Application Ref:	3/2020/01085	 <p>Ribble Valley Borough Council www.ribblevalley.gov.uk</p>
Date Inspected:	N/A pre-application	
Officer:	SK	
DELEGATED ITEM FILE REPORT:		REFUSAL

Development Description:	Proposed construction of two semi-detached bungalows with associated gardens and parking areas.
Site Address/Location:	Land at Bank Cottages Whalley Road Billington BB7 9NL

Drawing Title
 Proposed Site Plan

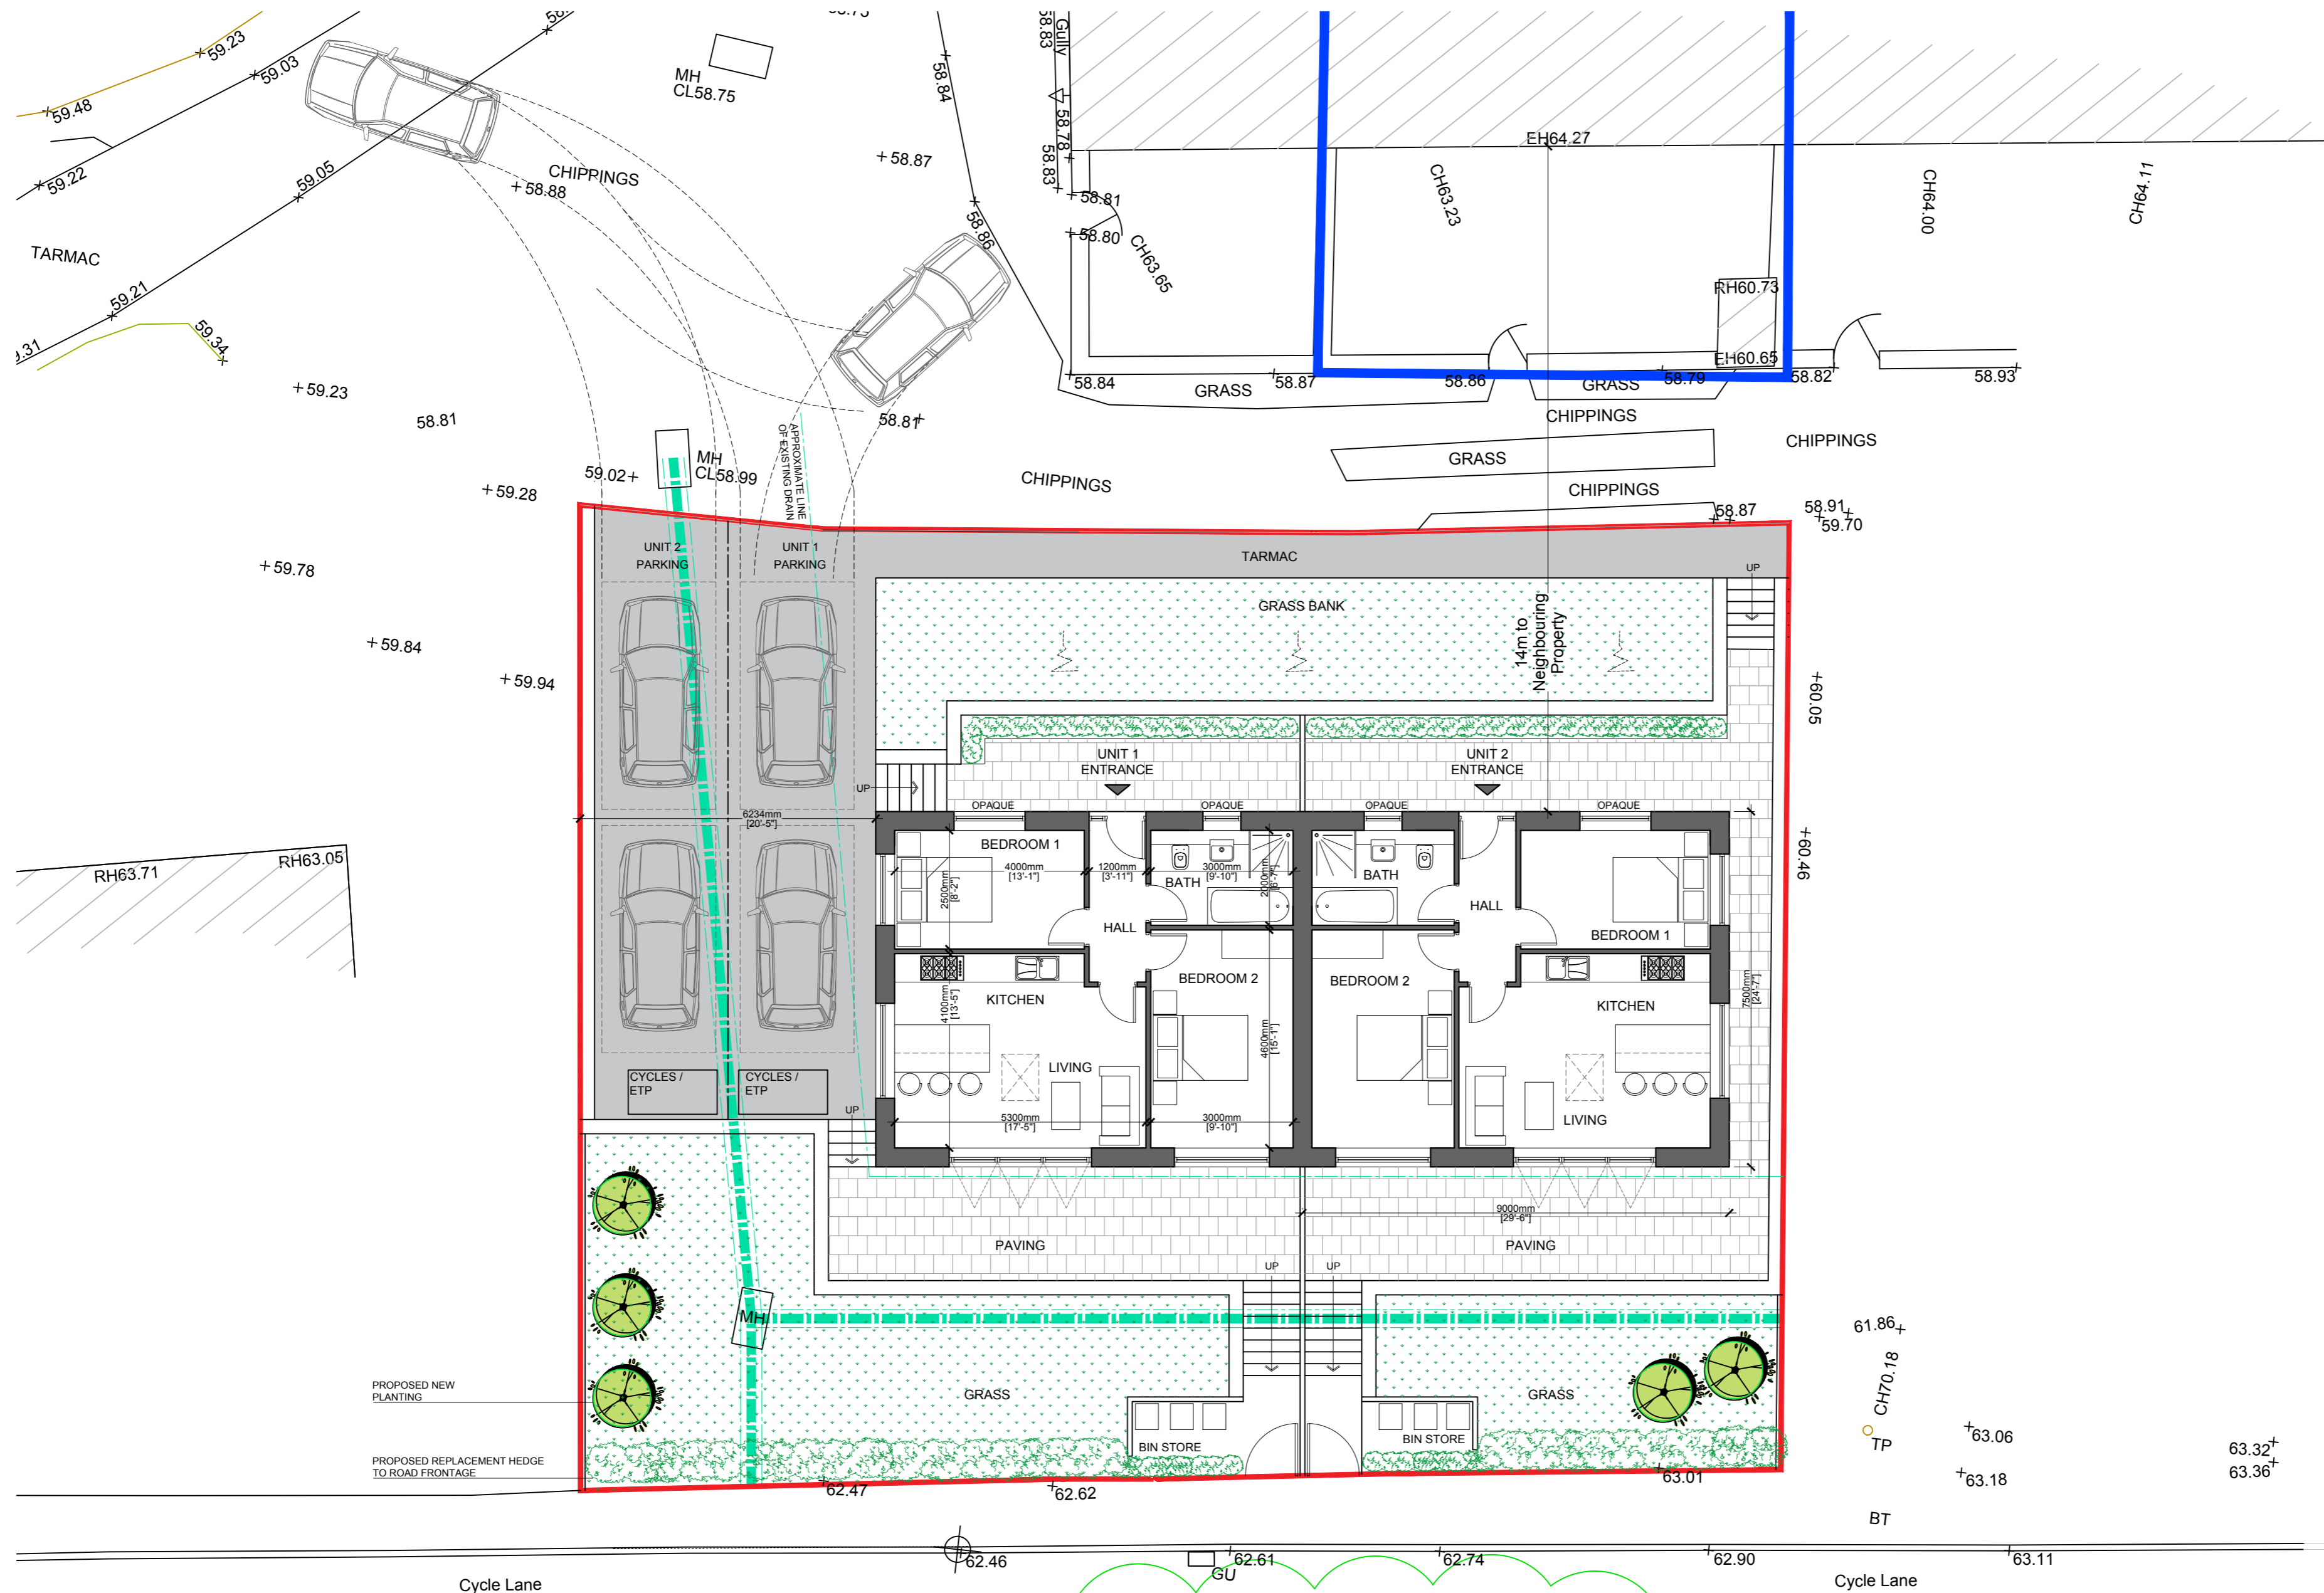
It is proposed that the dwellings will benefit from a spatial offset of 14m from the existing properties to the north, also being of a lower eaves and ridge height, it is noted that the proposed 14m offset distance

falls significantly short of the 21m back-to-back interface distance usually secured and required by the authority.

The proposal seeks to introduce development in a parcel of land that is largely devoid of significant structures and on an area of land that directly fronts Whalley Road. In this respect, when taking account of the inherent pattern of development within the vicinity and taking account of the level of visibility that the proposal will be afforded upon approach, it is considered that the proposal will be read as an incongruous introduction that fails to respond positively to the dominant pattern of development established by the terraced properties to the north.

Whilst the design and external appearance of the dwellings themselves are austere and simple in their character and as such are unlikely to be of an architectural language that would allow them to be read as unsympathetic or incongruous. It is the resultant pattern of development and the introduction of built form in to an area of land that is largely devoid of development that raises fundamental concerns insofar that it is not considered that the proposal will be visually assimilated into the area without being read as being anomalous or discordant.

| 01: | The proposal is considered contrary to Policies DMG1 and DMG2 of the Ribble Valley Core Strategy by virtue of the density of the proposed developable parcels, cumulative overall density, the quantum of development proposed and its location, which would result in an anomalous and discordant pattern of development that fails to respond positively to the inherent pattern and density of adjacent built-form and fails to be well-related to the main built up area of the settlement of Whalley, being of detriment to the character and visual amenities of the area. |

Drawing Title  
 Proposed Elevations and Section  
 Scale  
 1:100 @ A3  
 Date  
 Nov 2020  
 Drawn  
 BT

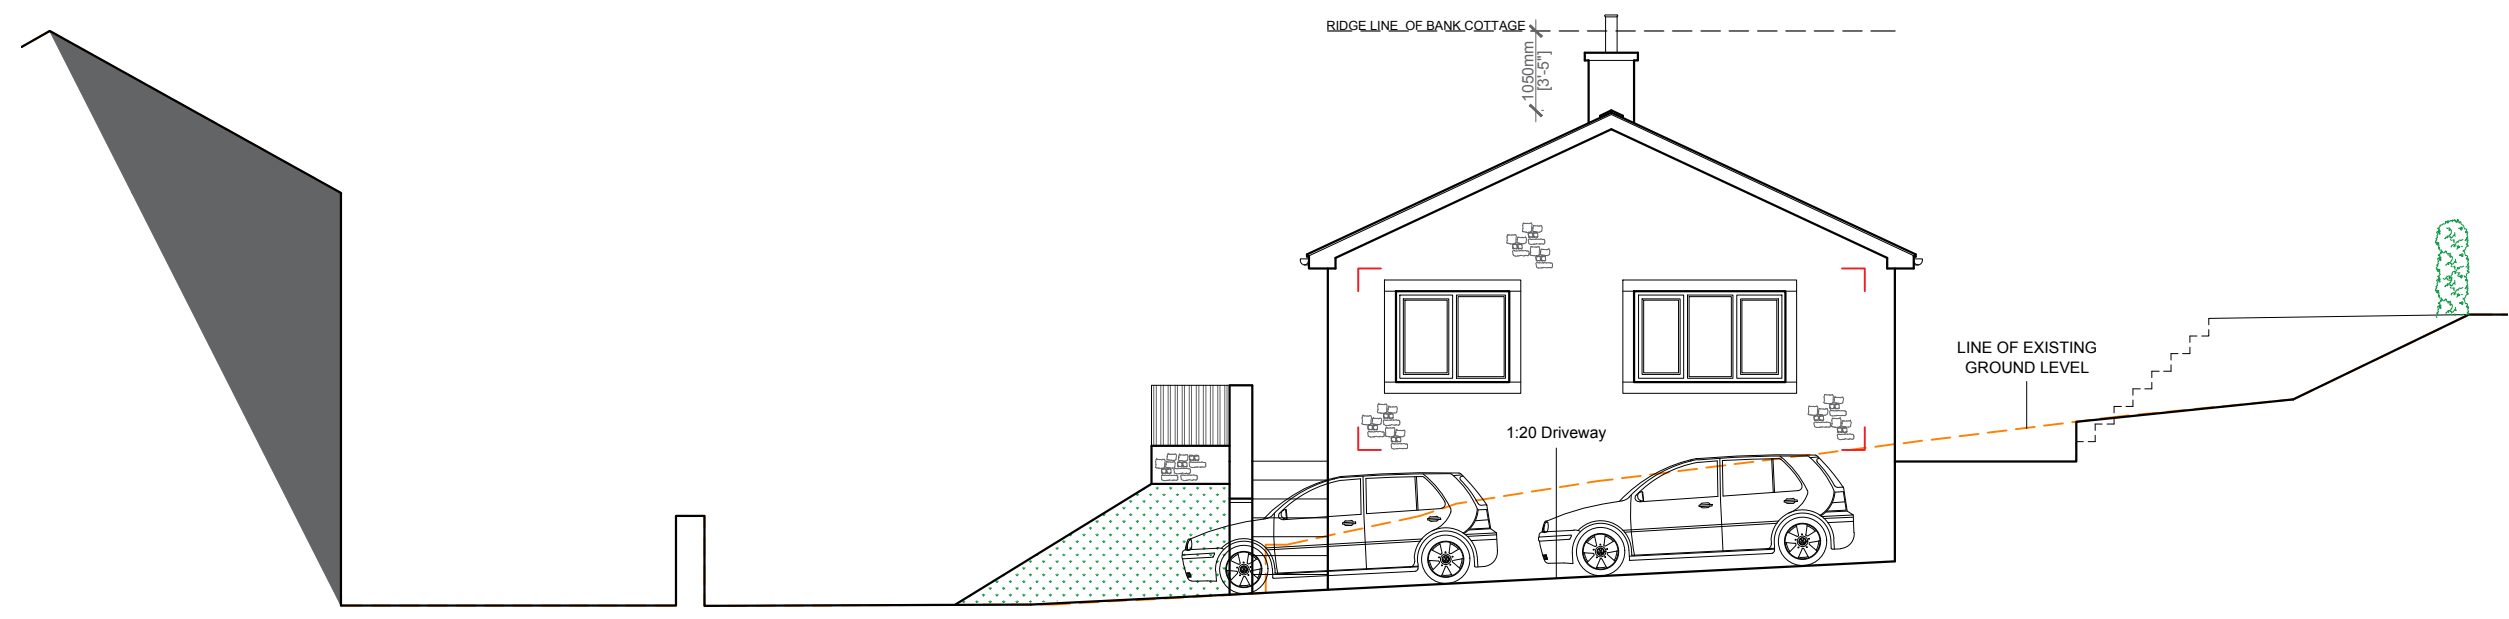
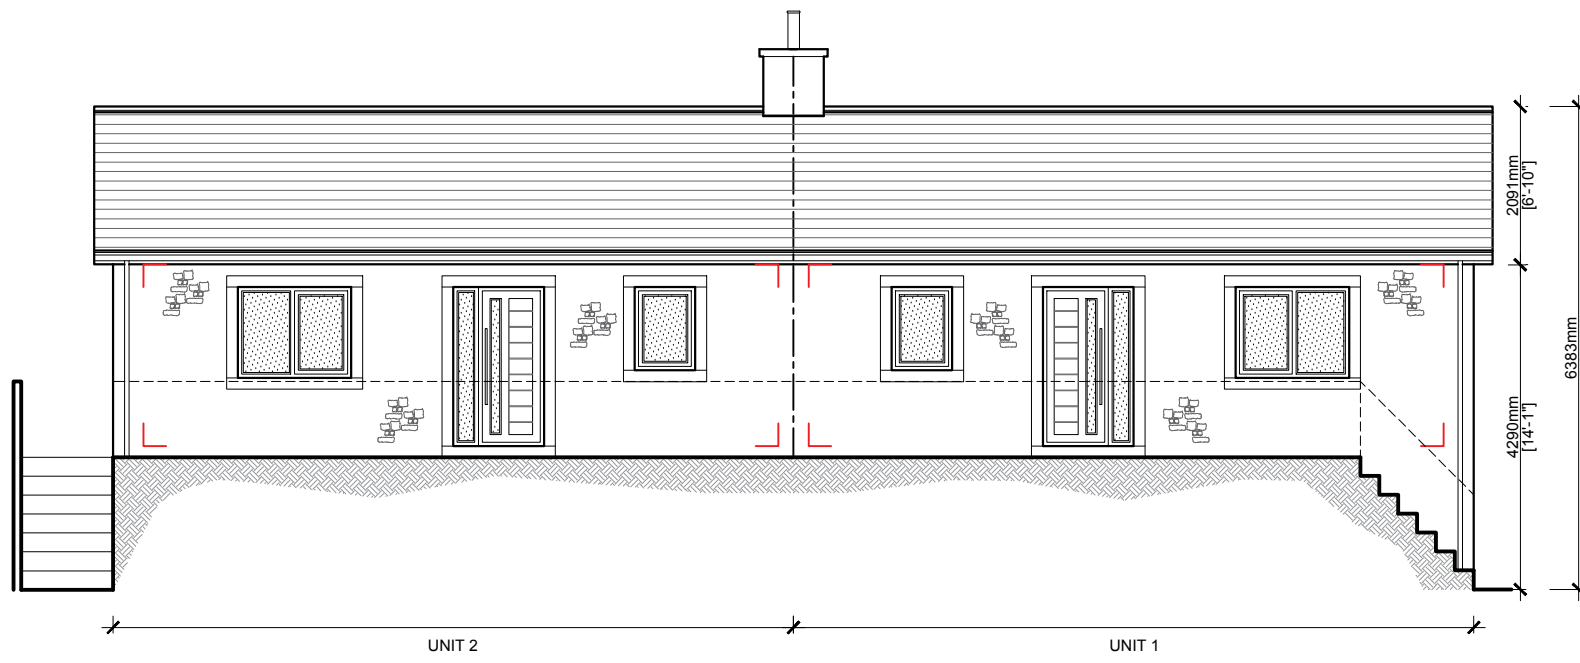
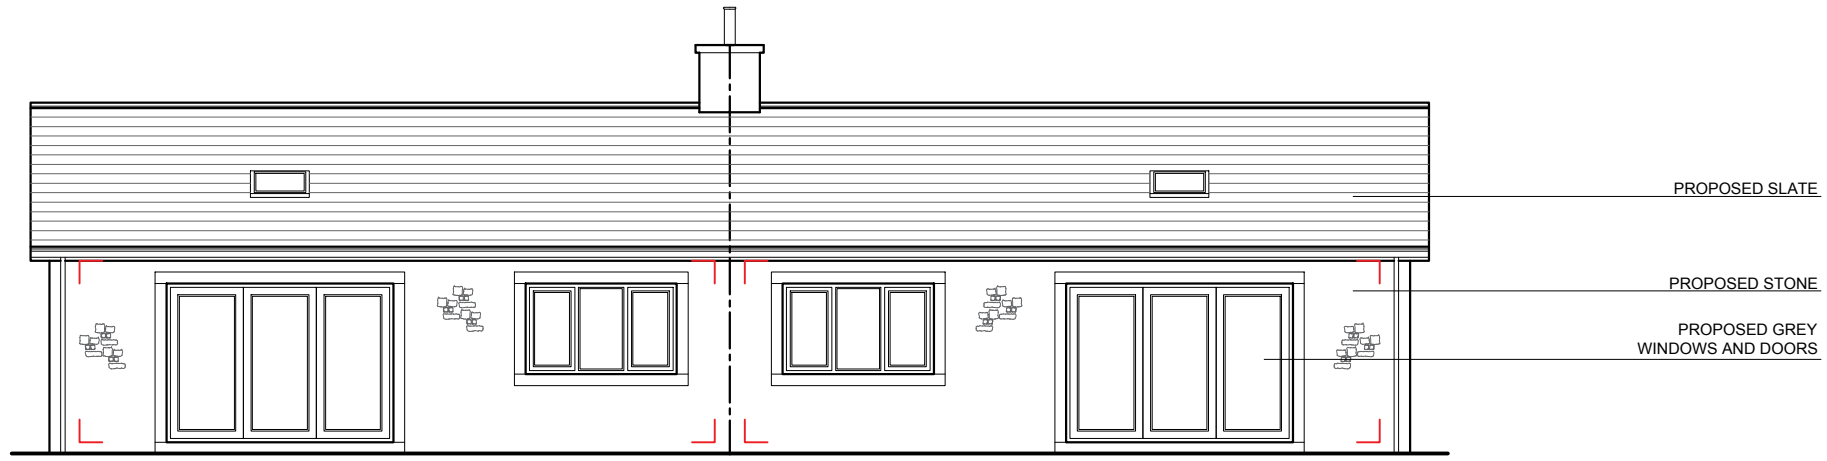
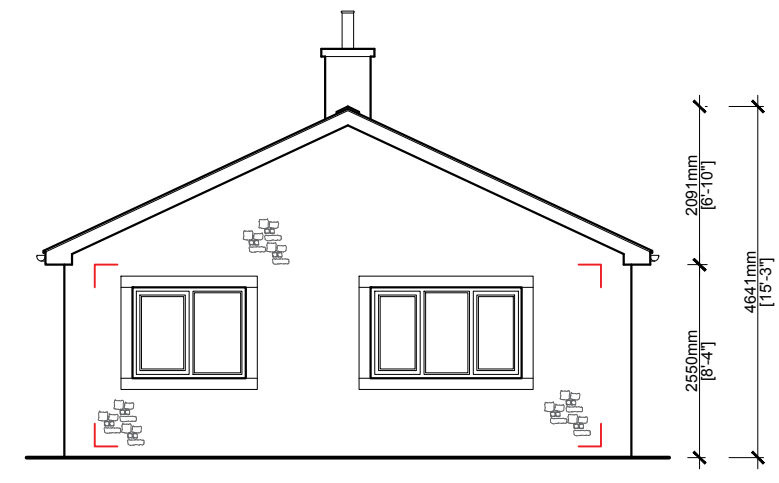
It is proposed that the dwellings will be faced in natural stone with slate roofing. The submitted sectional details show that the eaves and ridge height of the prospective dwellings will be lower than

that of their neighbouring counterparts to the north. It is further proposed that all northerly facing windows serving the dwelling will be obscure glazed to mitigate potential overlooking of the properties to the north and their respective private garden areas.

However, it should be noted that the north-facing elevations of the proposed dwellings, that will have a direct-facing relationship with Bank Cottages, contains only windows and glazing that is proposed to be obscure glazed. In this respect the interface between the existing and proposed properties, in terms of outlook-interface and the inter-visibility of occupiers from habitable rooms is fully mitigated.

Taking account of the above, consideration must still be given in respect of the potential for an over-bearing impact or an unsympathetic relationship with the properties to the north. The proposed northerly window arrangement, by virtue of a lack of windows that benefit from an outward northerly aspect, is considered to therefore be akin to an arrangement whereby a rear elevation (existing or proposed) benefits from a direct visual interface with a flank (gable) wall or elevation. In such arrangements the authority would normally seek to secure a 13.5m offset distance in such circumstances. Given the submitted details propose an offset-distances of 14m it is clear that the proposal aligns with and exceeds the minimum tolerances that would normally be sought to mitigate the potential for an over-bearing impact or unsympathetic relationship.
